DRB CASE ACTION LOG (FINAL PLAT)

DRB Application No.: **05DRB-01502 (FP)**
Project Name: **ATLANTIC & SANTA FE SUBD.**
Agent: Greater Albuq. Housing Partnership

**City Of Albuquerque
PLANNING DEPARTMENT
October 5, 2005
DRB Comments**

RE: Baca Addition/final plat

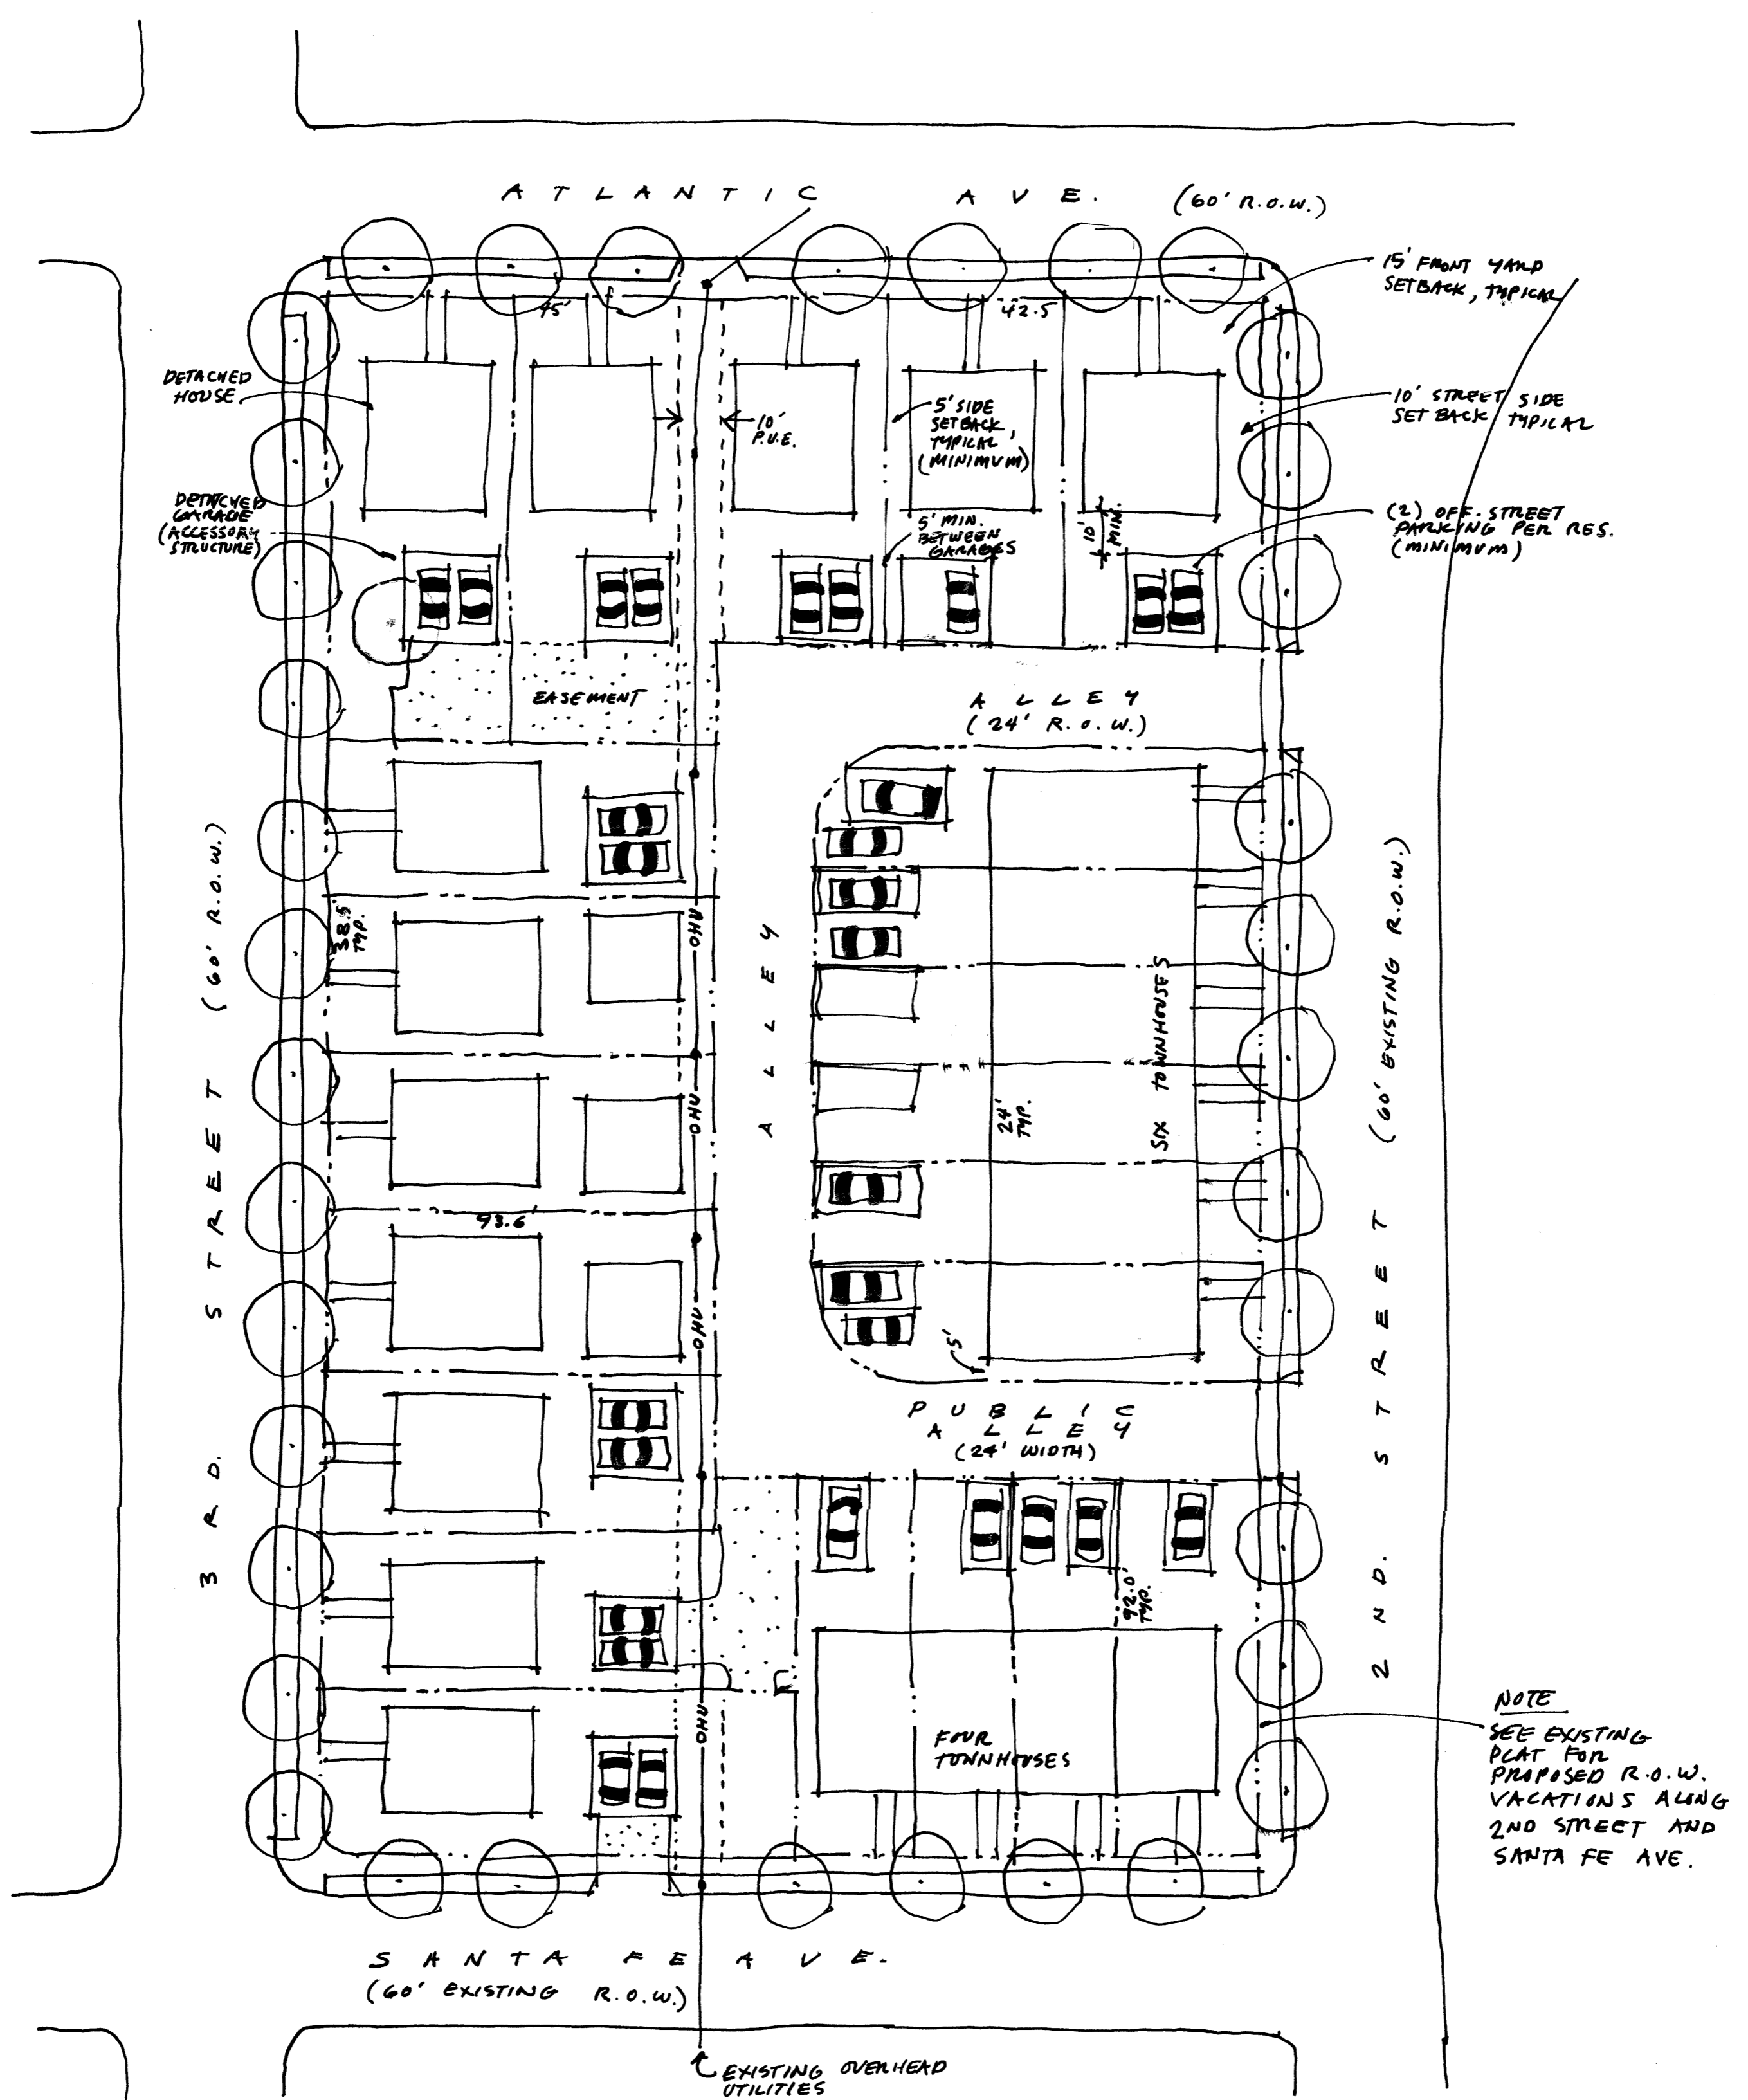
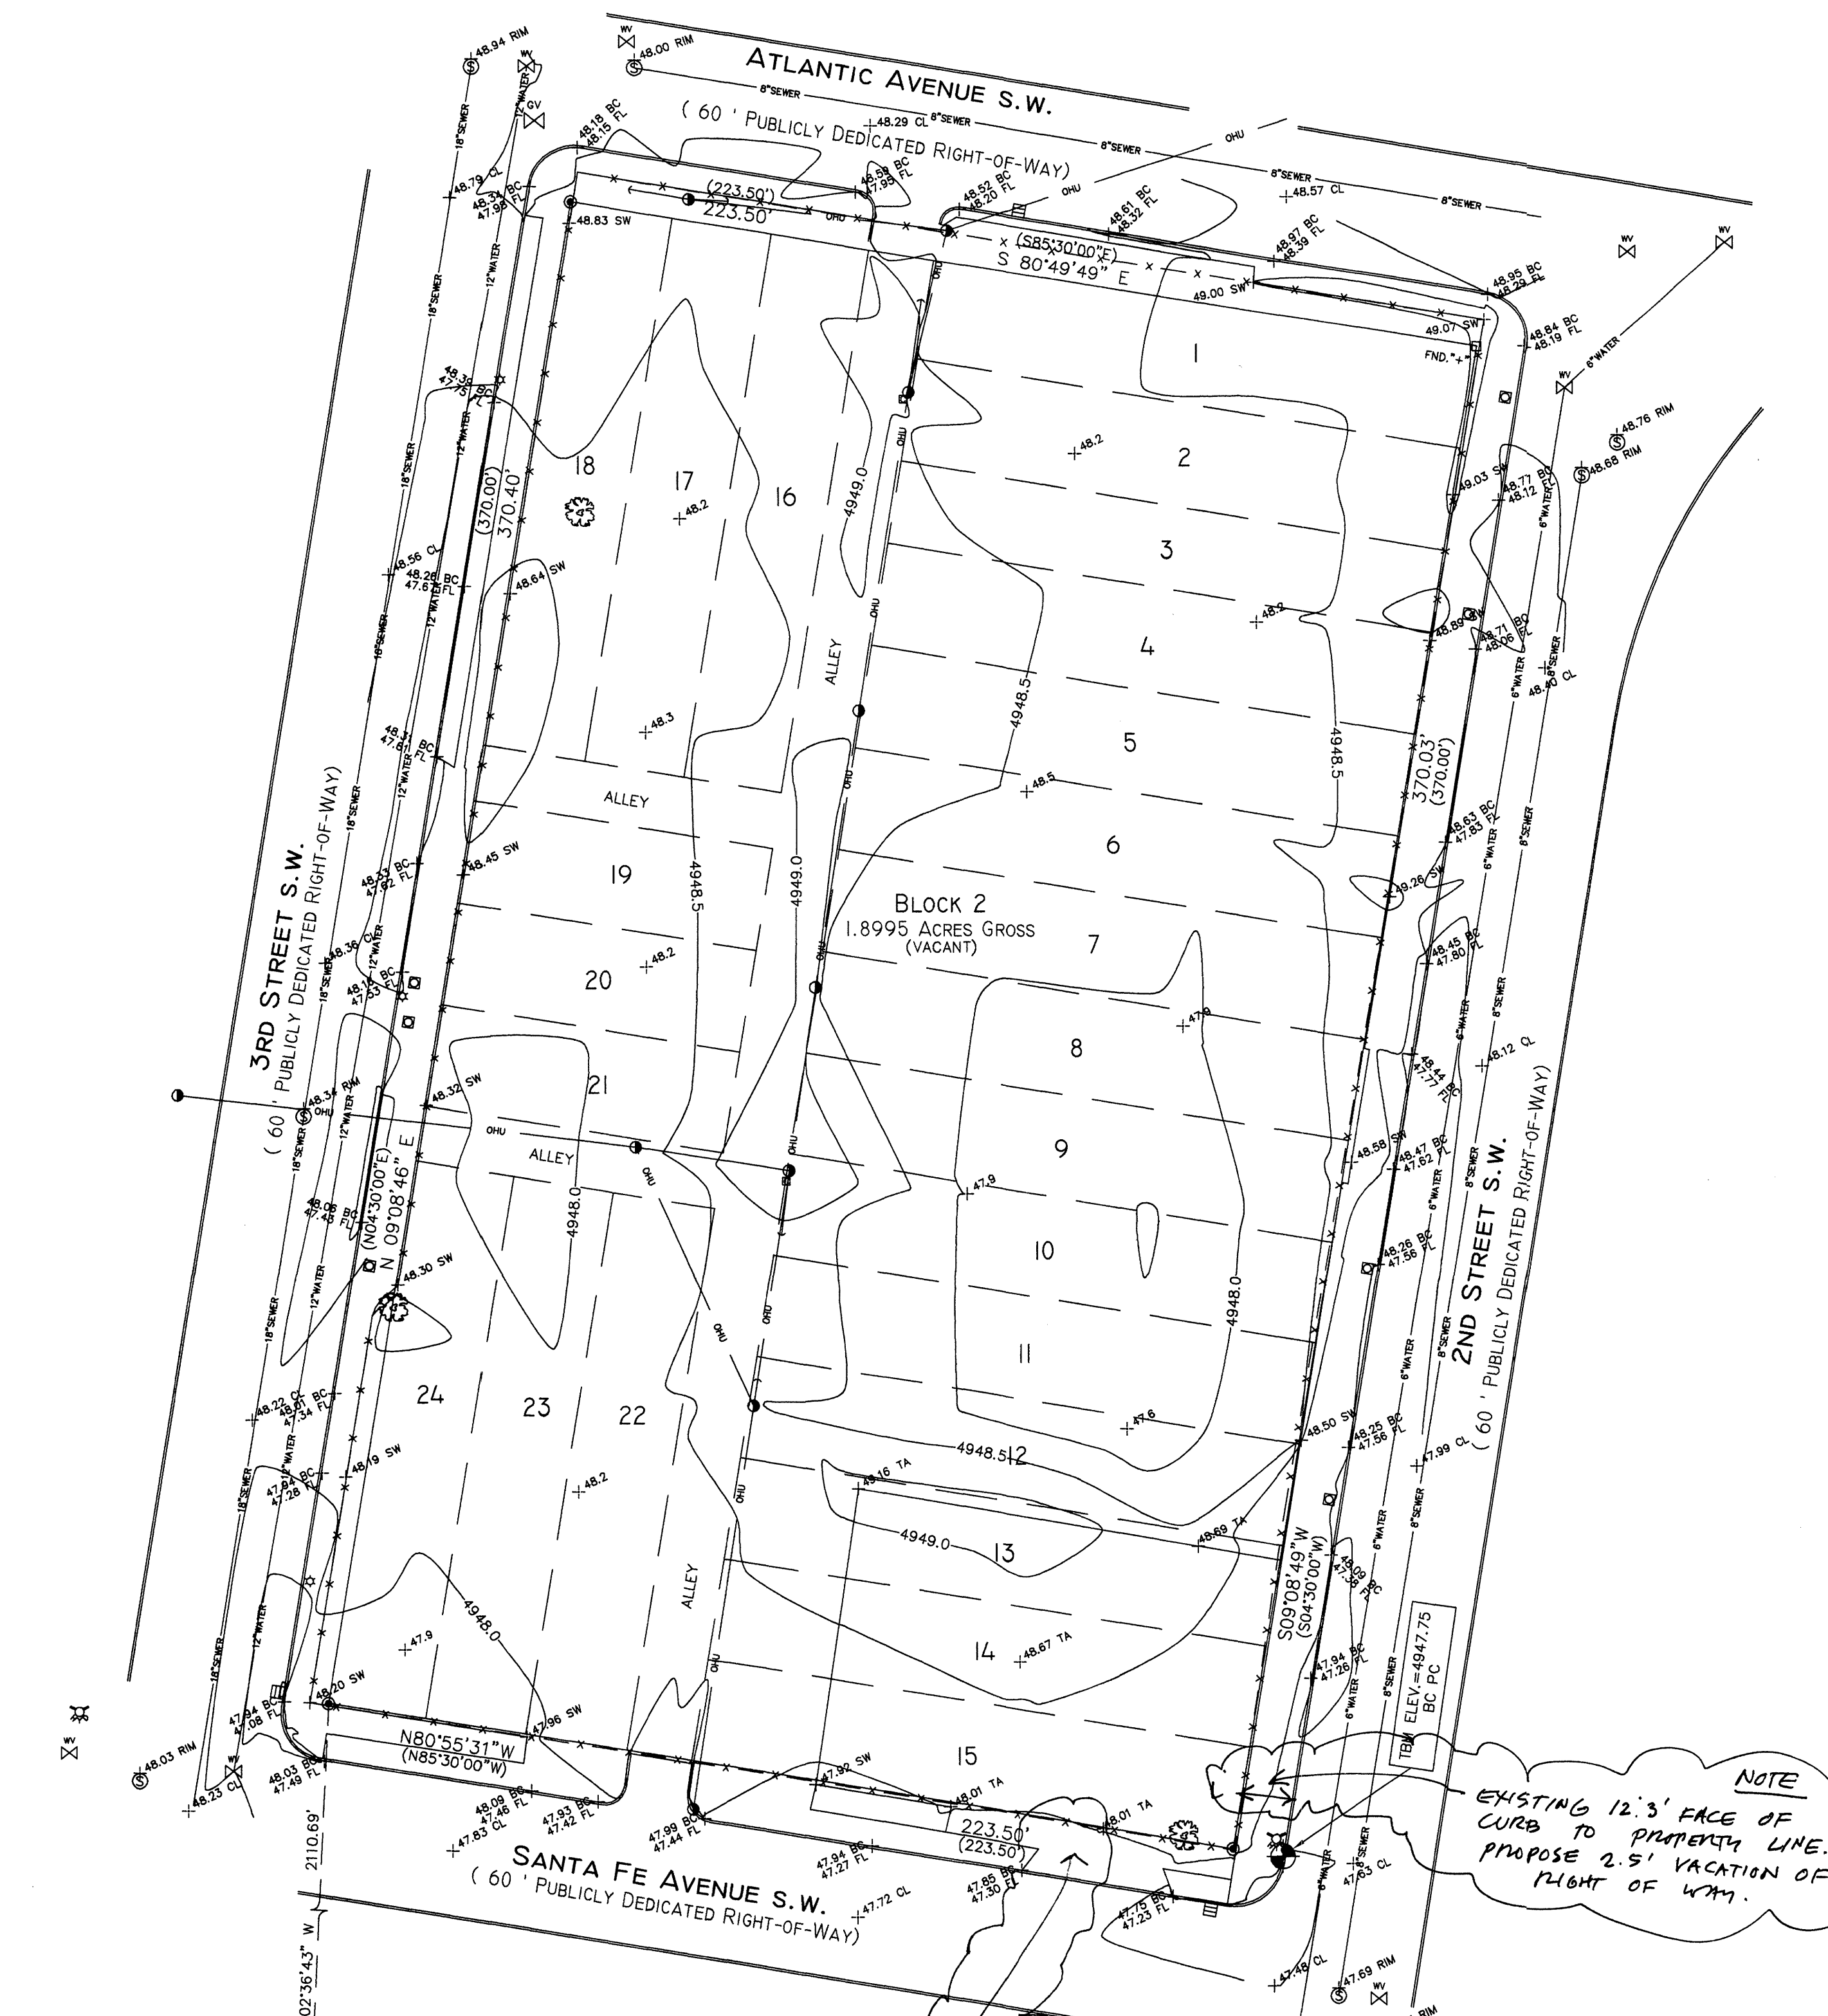
- TRANSPORTATION: _____
- Need 10' wide private sanitary sewer for benefit and maint. of lots 1, 2, 3 } ok
- _____ } SWA
- DEC PLANS SHOWING CURB SW & PROPERTY LINES

- PLANNING (Last to sign): Lot size requirements (Lot 10) legislation
- Record plat
- _____
- _____

Lot 10 does not meet the minimum lot size requirement of 3600 square feet in the RG zone. Changing this lot size was a condition of Final Plat Approval.

Planning can not approve a plat with a substandard lot.

The final plat shall show Lot 10 with 3600 sq. ft. minimum lot size.
